# **COUNTY COUNCIL'S RESPONSE TO CONSULTATION ON THE FOLLOWING DEVELOPMENT PROPOSAL**

**Application No:** 17/02522/ M106

**Proposal:** Modification of Section 106 - Application 10/01780/HYBRID

**Location:** Bicester Eco Town Exemplar Site Caversfield Oxfordshire

Title: **Street Furniture Cycle Stand**

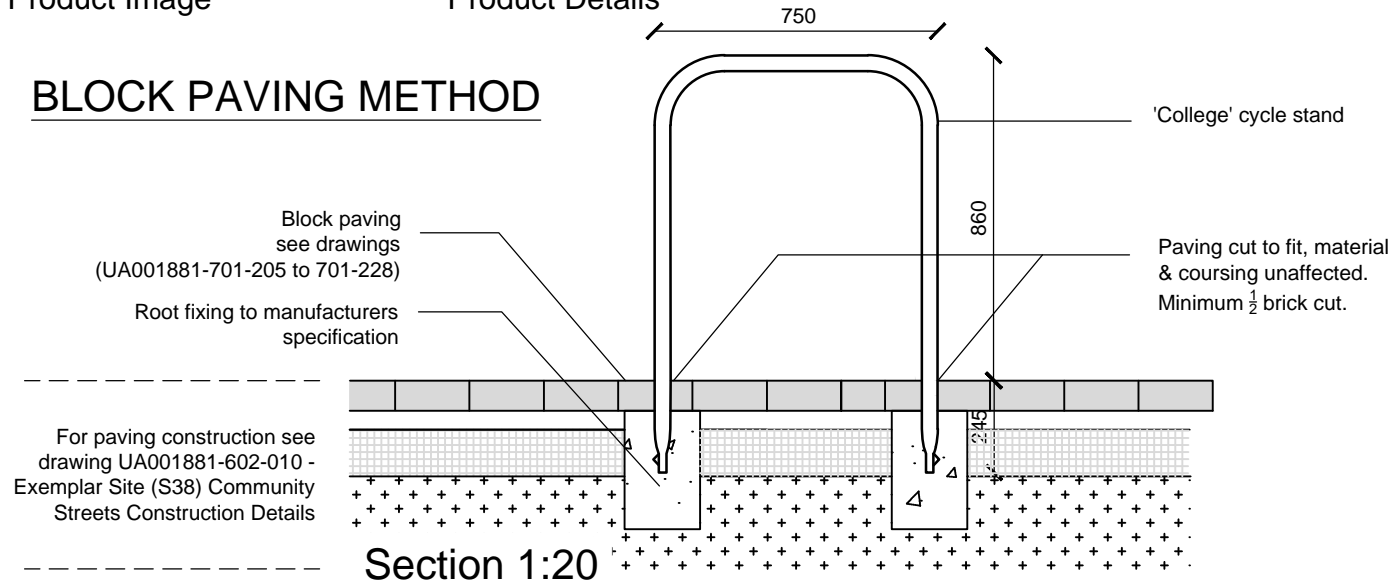
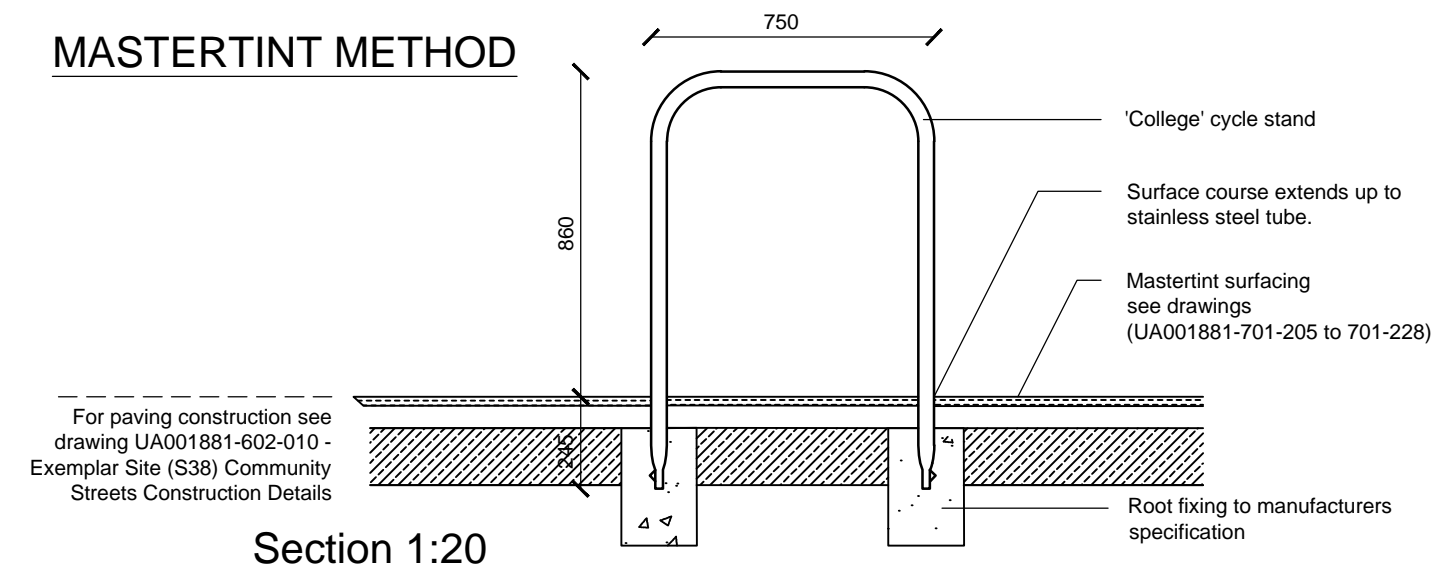
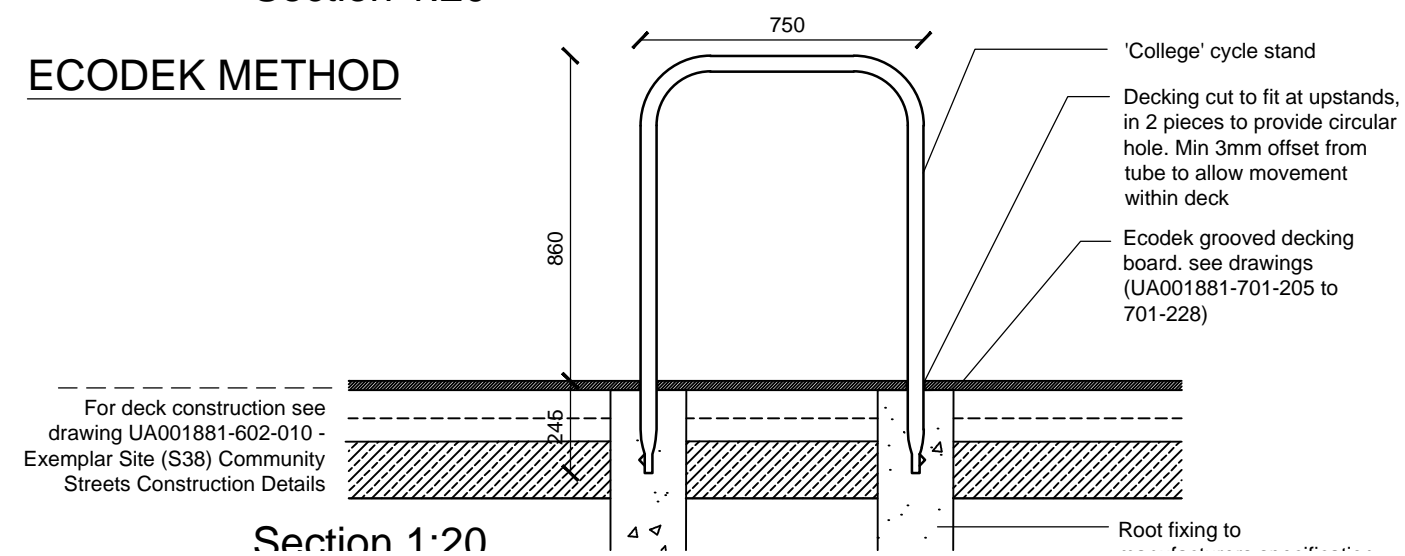
- Further clarification is required around cycle parking (17th Schedule off Site Highway Work Part 2 Clause 4).
- Further discussion is needed on monitoring the bus only route (18th Schedule, Clause 4.2)
- Further detail is required regarding proposal for direct delivery of the cycle scheme (20th Schedule, Clause 3.1).
